Reference: MP 08\_0155 Quest Serviced Apartments Sydney Olympic Park

Please find below my response to the Design Review Panel (DRP) comments for the above project dated 28<sup>th</sup> October 2010 in regards to your S75W submission.

Roof Plan
1 : 100

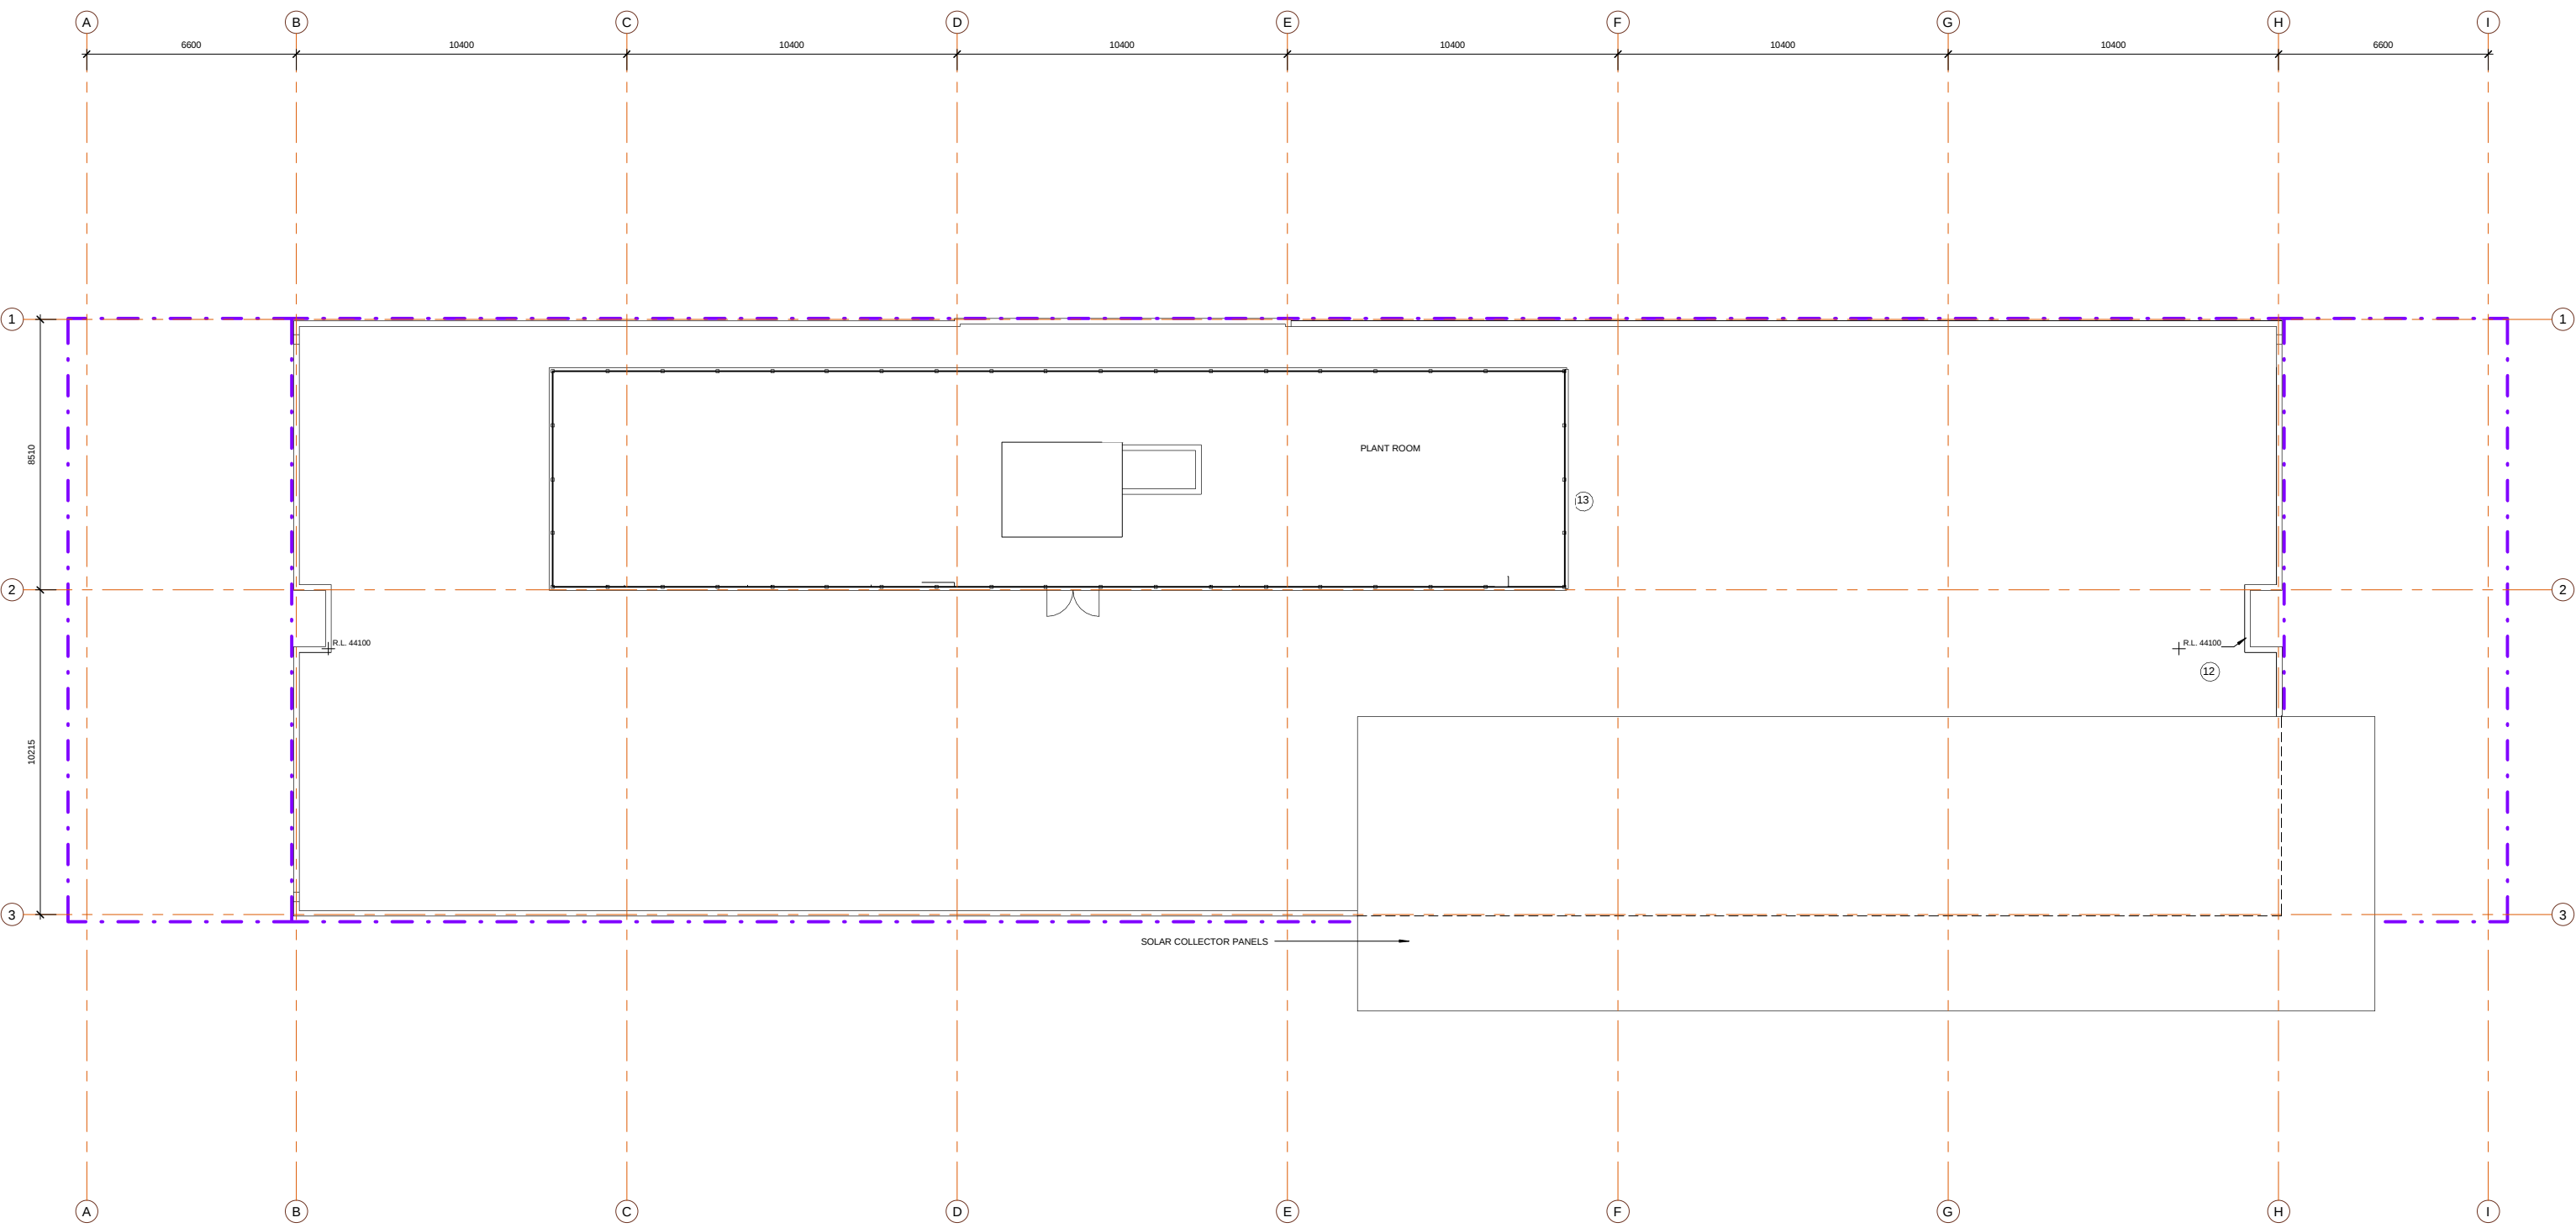
*"No separation between roof parapet and projecting canopy."*

*"Preserve the separation between the projecting canopy and the top of the roof parapet."*

The separation between the roof parapet and the projecting canopy has been reinstated to match the previously approved design.

The separation between the roof parapet and projecting canopy has been reinstated to match the approved design.

Project
QUEST - SYDNEY OLYMPIC PARK
EDWIN FLACK AVENUE, HOMEBUSH BAY, NSW 2127
Drawing Title
West Elevation

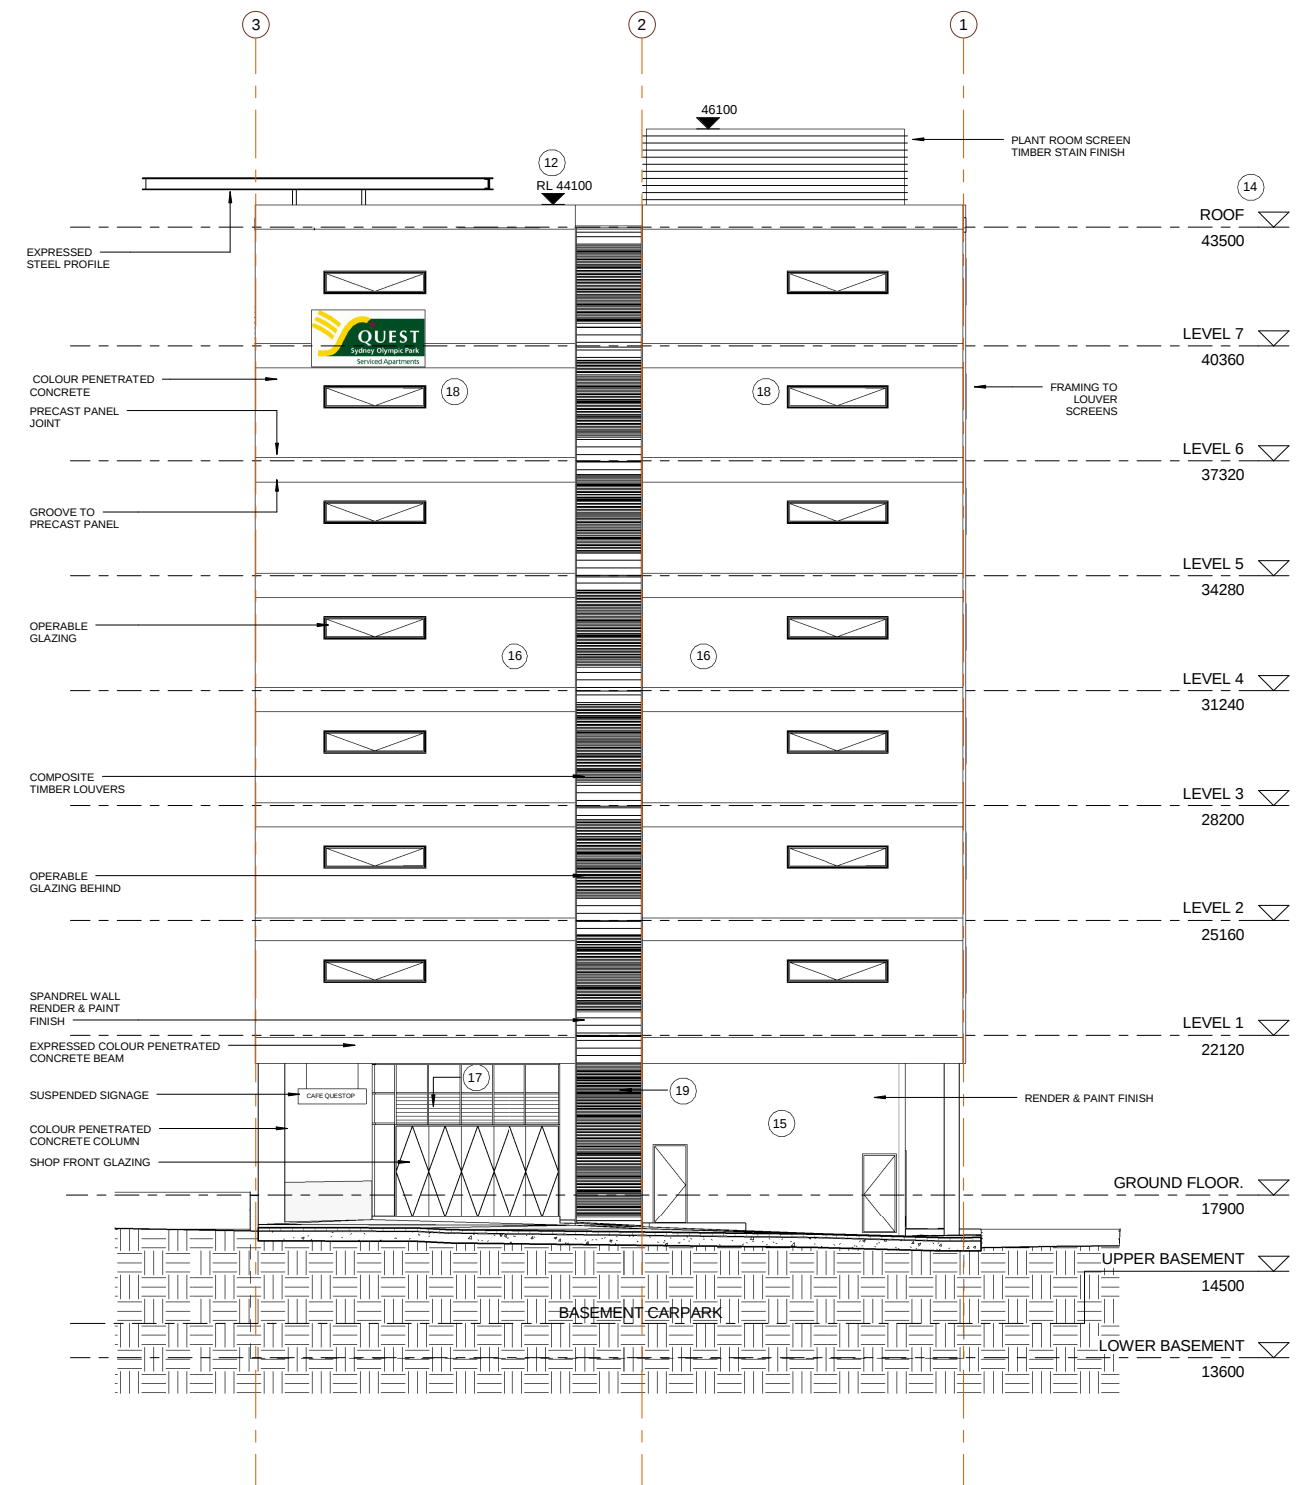
*"The lack of variety to the revised west elevation due to the removal of operable louvers and standardization of structure."*

*"Proposed timber louvers on the western elevation are visually weak and ineffective in screening the exposed windows."*

*"Improve animation of the western elevation to reestablish the variety of the approved design."*

*"Modify the timber louver screen on the west elevation to improve performance and increase visual impact on that frontage."*

The variety to the South-West facade has been increased. In a random pattern solid balustrades have been introduced. The composite timber louvers have been replaced in conjunction with an extension of the colour scheme to add to the variety and improve the design quality. Grooves have been added to the precast elements to further enhance the design.

The timber louvers have been amended removed. The windows to the ensuites have been removed. Due to the use of double glazed units screening to the bedroom windows is not required.

The animation of the western elevation has been improved.  
In a random pattern solid balustrades have been introduced, the colour scheme has been extended and the precast concrete received a false groove design to add to the variety and improve the design quality.

The timber louvers on the West elevation were not needed for performance due to the use of double glazed units throughout the building. Hence they have been removed and the balcony colour scheme has been extended to this part of the Western facade to achieve an integrated design solution. In addition false grooves have been added to the precast elements to increase the visual quality on that frontage.
